Environmental Health Division  
1675 W. Garden of the Gods Road  
Suite 2044  
Colorado Springs, CO 80907  
(719) 578-3199 *phone*  
(719) 578-3188 *fax*  
[www.elpasocountyhealth.org](http://www.elpasocountyhealth.org)

### Crystal Park Site S-124 (R), CP-21-7

Please accept the following comments from El Paso County Public Health regarding the project referenced above:

22

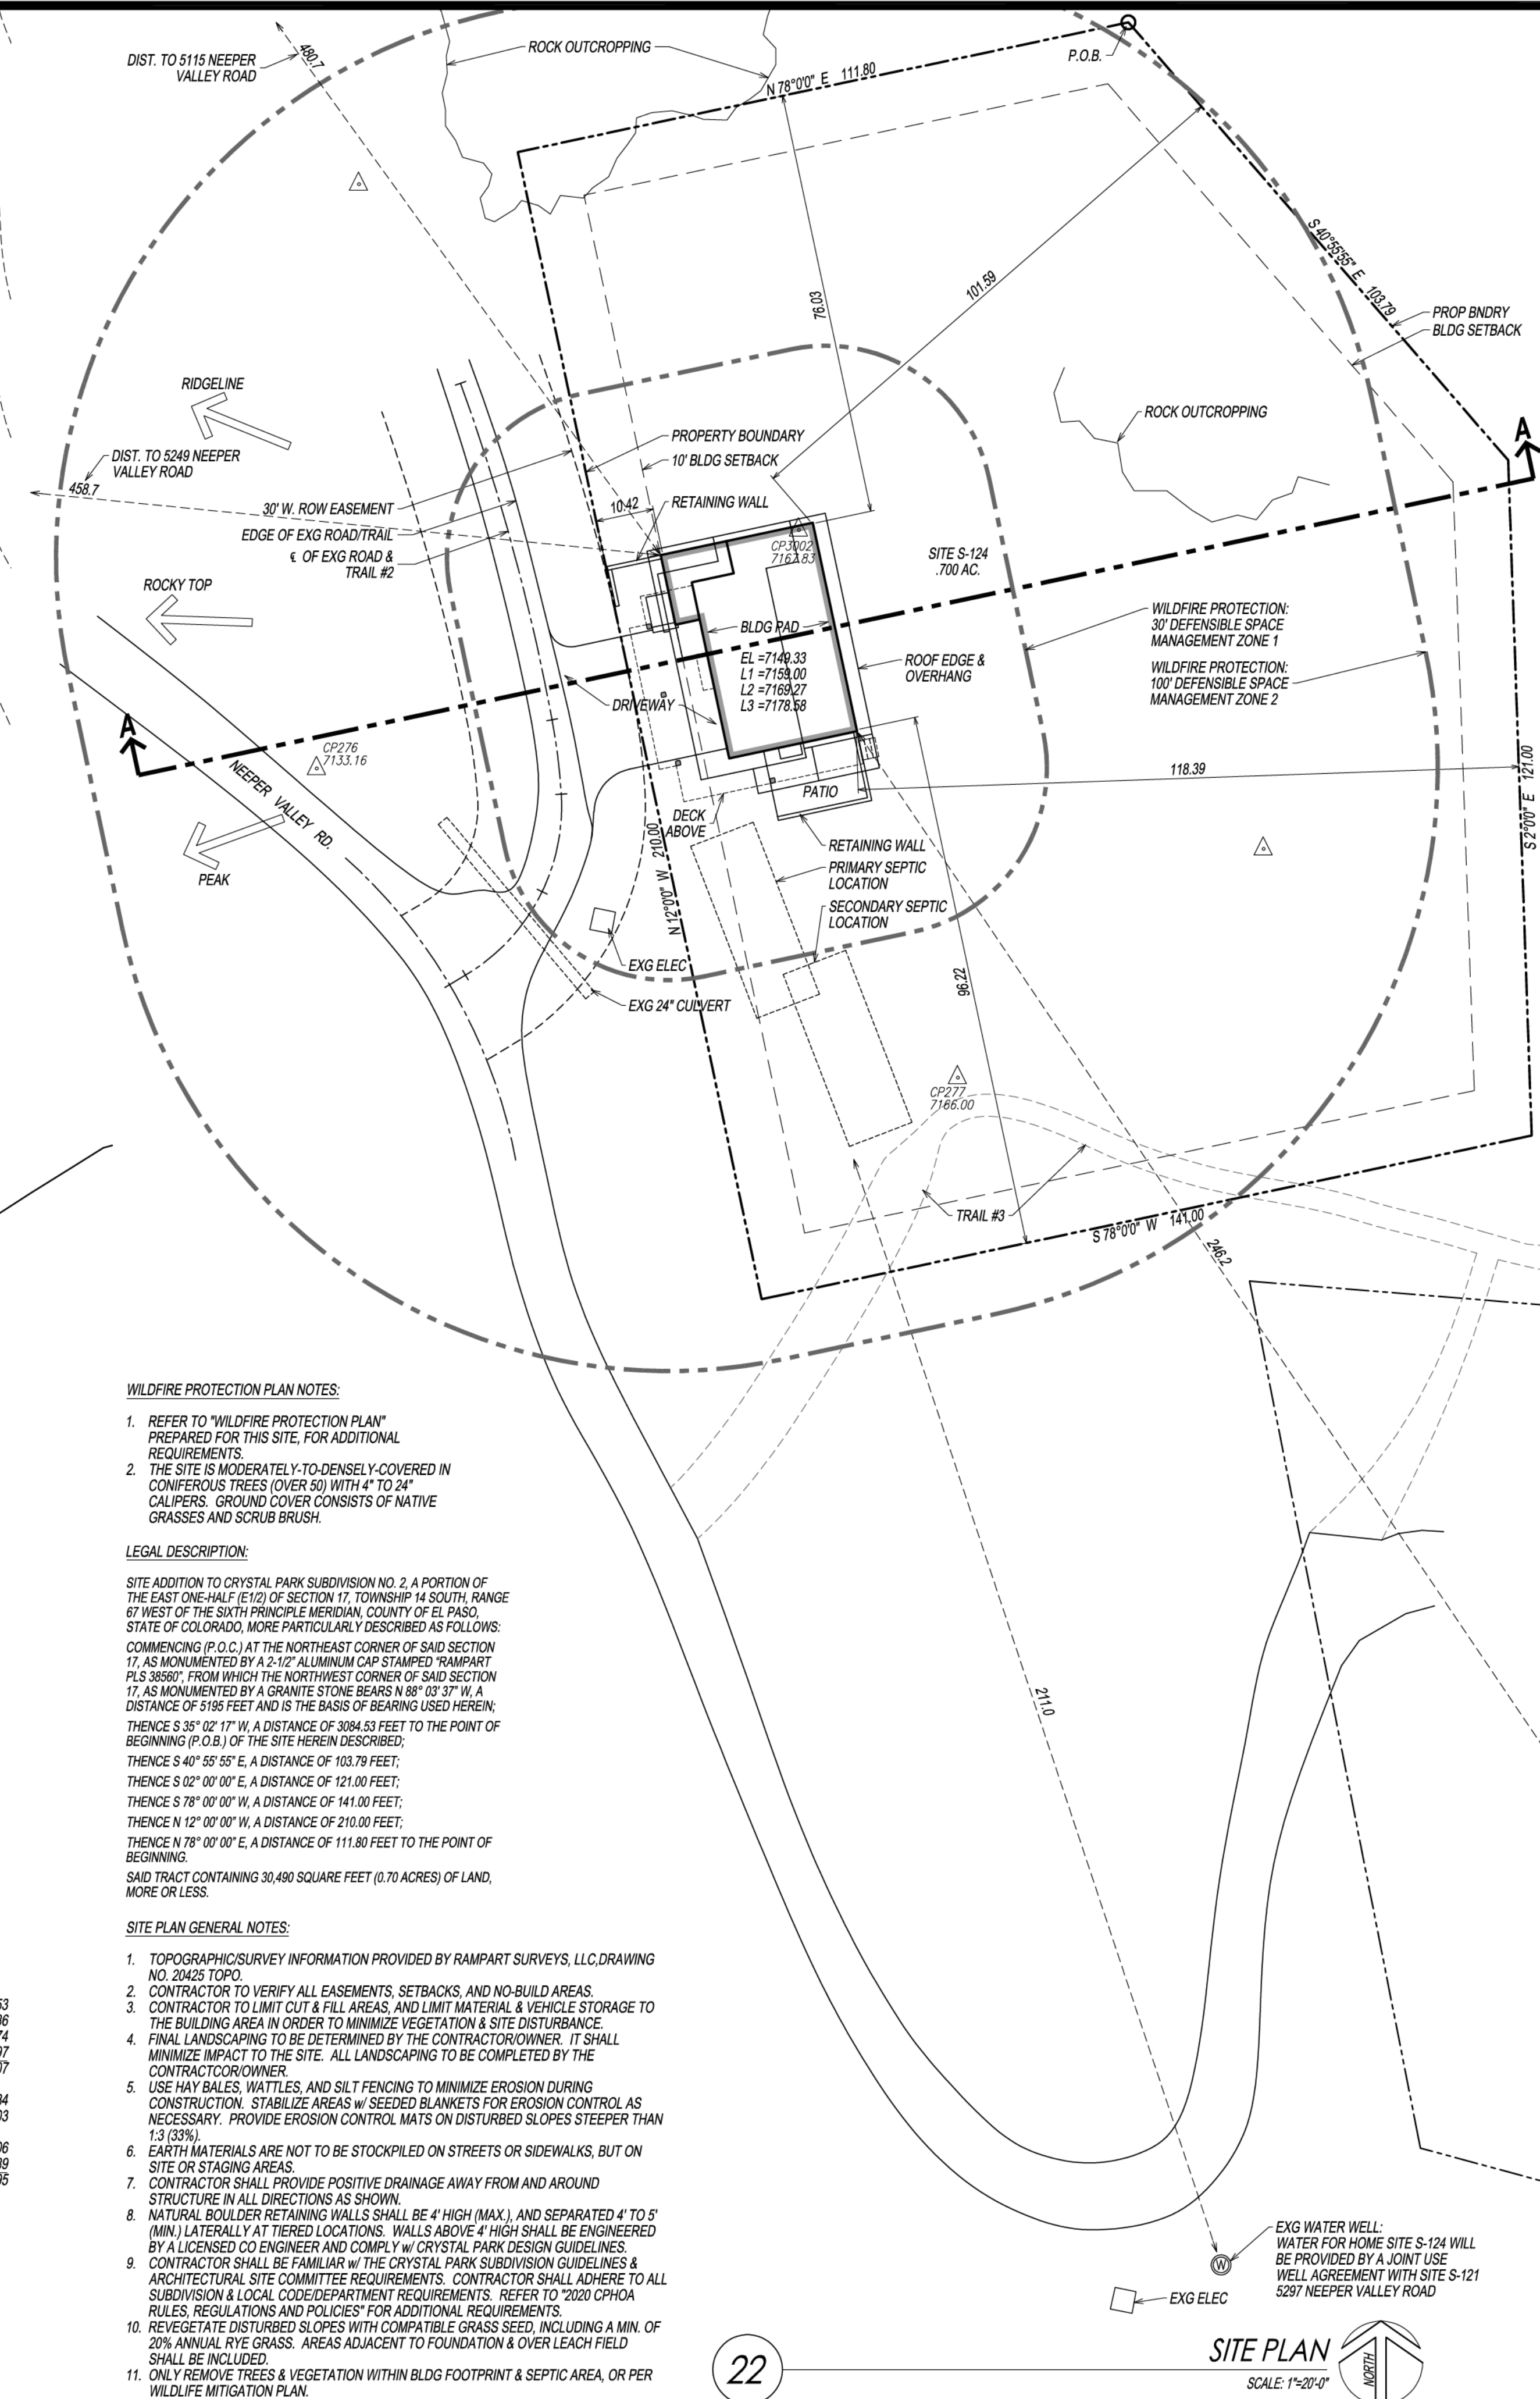
- **The site development plan indicates areas for both a primary soil treatment area (STA) site and an alternate STA. The OWTS must meet all current El Paso County Public Health OWTS Regulations. Please be aware that a vertical STA or “seepage pit or drywell” is the last type of STA to be considered for approval. The results of the soil test in these areas will determine the types of STA’s to be considered for approval.**

- **The STA’s must be 100’ minimum from any well, internal or external, and also must be protected from all house construction and site development activities. Compaction of the STA by such activities may cause the area to be unsuitable for use. Recommend fencing the area during construction to minimize the potential for soil compaction. Adjacent property well locations were not shown on the Site Plan; therefore, be aware of the specific 100’ setback requirements.**
